RE: Double K Short Plat (SP-16-00005)

The Kittitas County Community Development Services Department has determined that the Double K. Ranch Short Plat (SP-16-00005) is a complete application and hereby grants *conditional preliminary approval* subject to the following conditions:

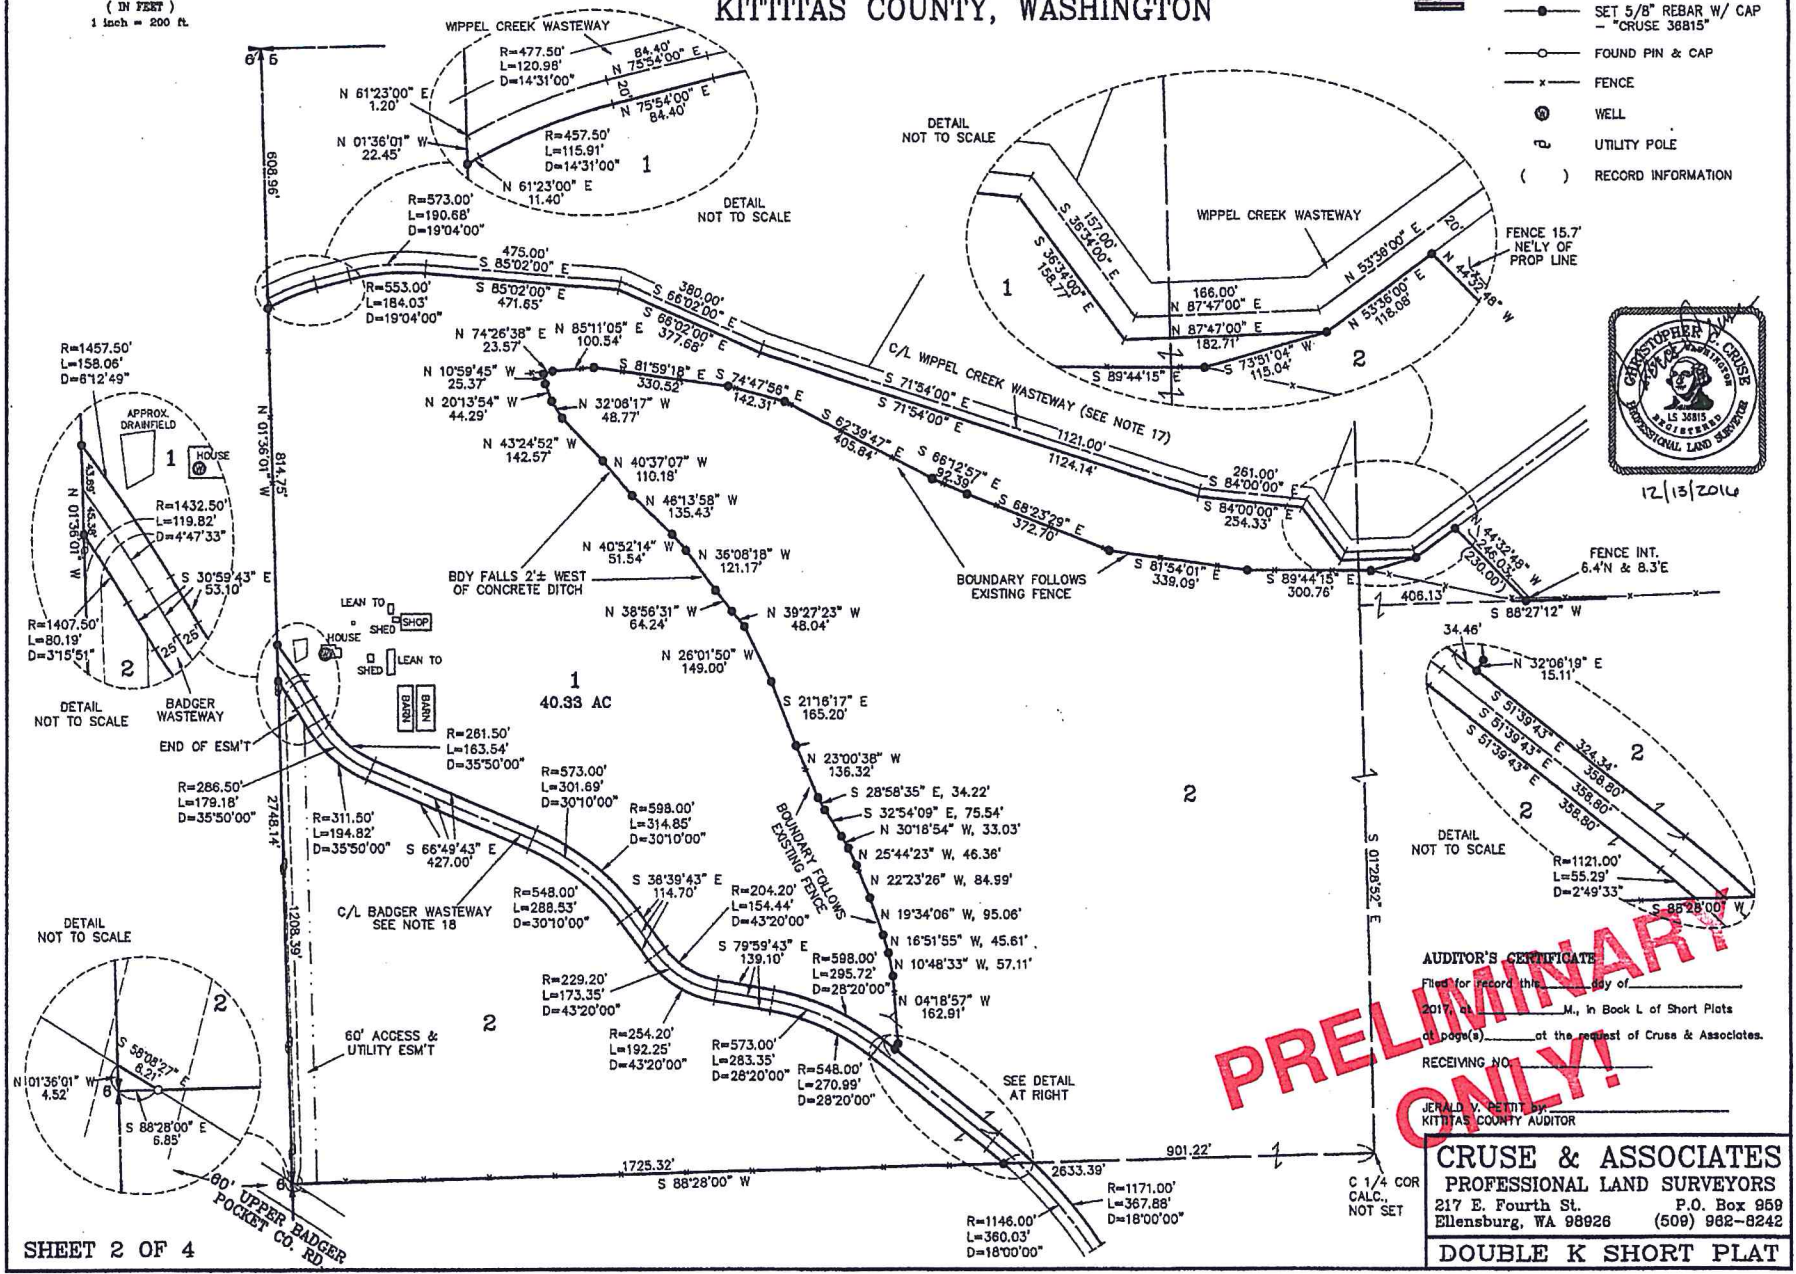
23. All Floodplains and wetlands shall be delineated on the face of the final mylar.
24. The name Badger Wasteway shall be changed to Badger Creek on the surveys to reflect the natural water course.

25. A critical areas buffer and setback shall be shown in the survey for Wippel Wasteway and Badger Creek.
26. The dashed lines adjacent to the West boundary of Section 5, within the 60' Access easement should be identified. It is assumed these lines represent a driveway, but that should be clarified.

27. The 60' easement adjacent to the West boundary of Section 5 shall be labeled as "Existing", "Herein Dedicated", or "Created via separate document". If the first of third option is used, the Auditor's File No. shall be included. It should be noted that the easement as shown does not connect to Badger Pocket Road with the full 60' width.

ORIGINAL PARCEL DESCRIPTION

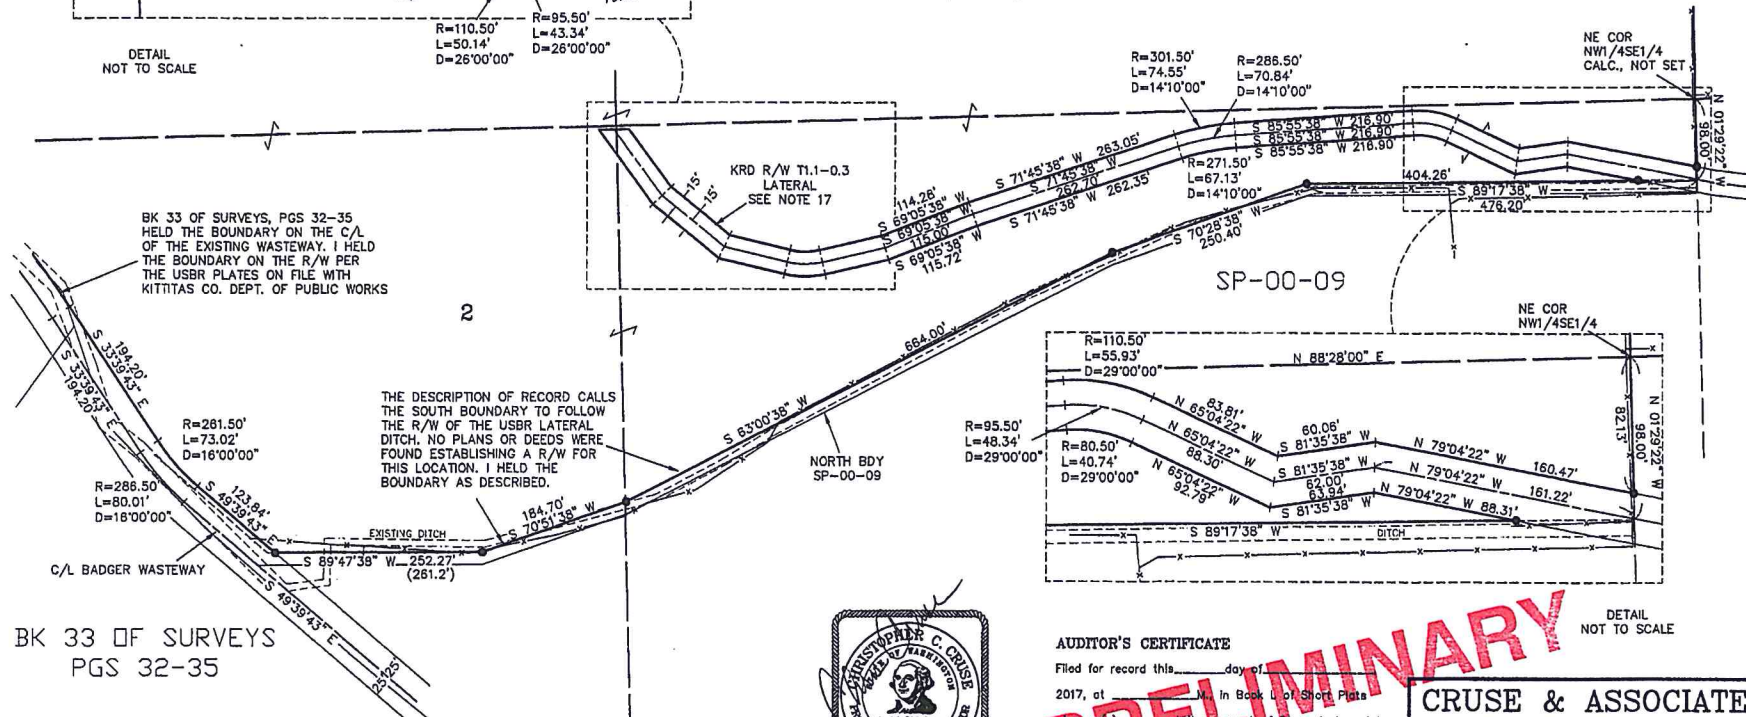
28. Any submittal which uses contours or elevations shall include a reference to the vertical datum used.
29. The following corrections shall be made to the legal description:

Paragraph 2, Line 5: Southeast corner thereof, and **thence** East...

Paragraph 2, Line 6: to the center section line; thence **North** 89-59...
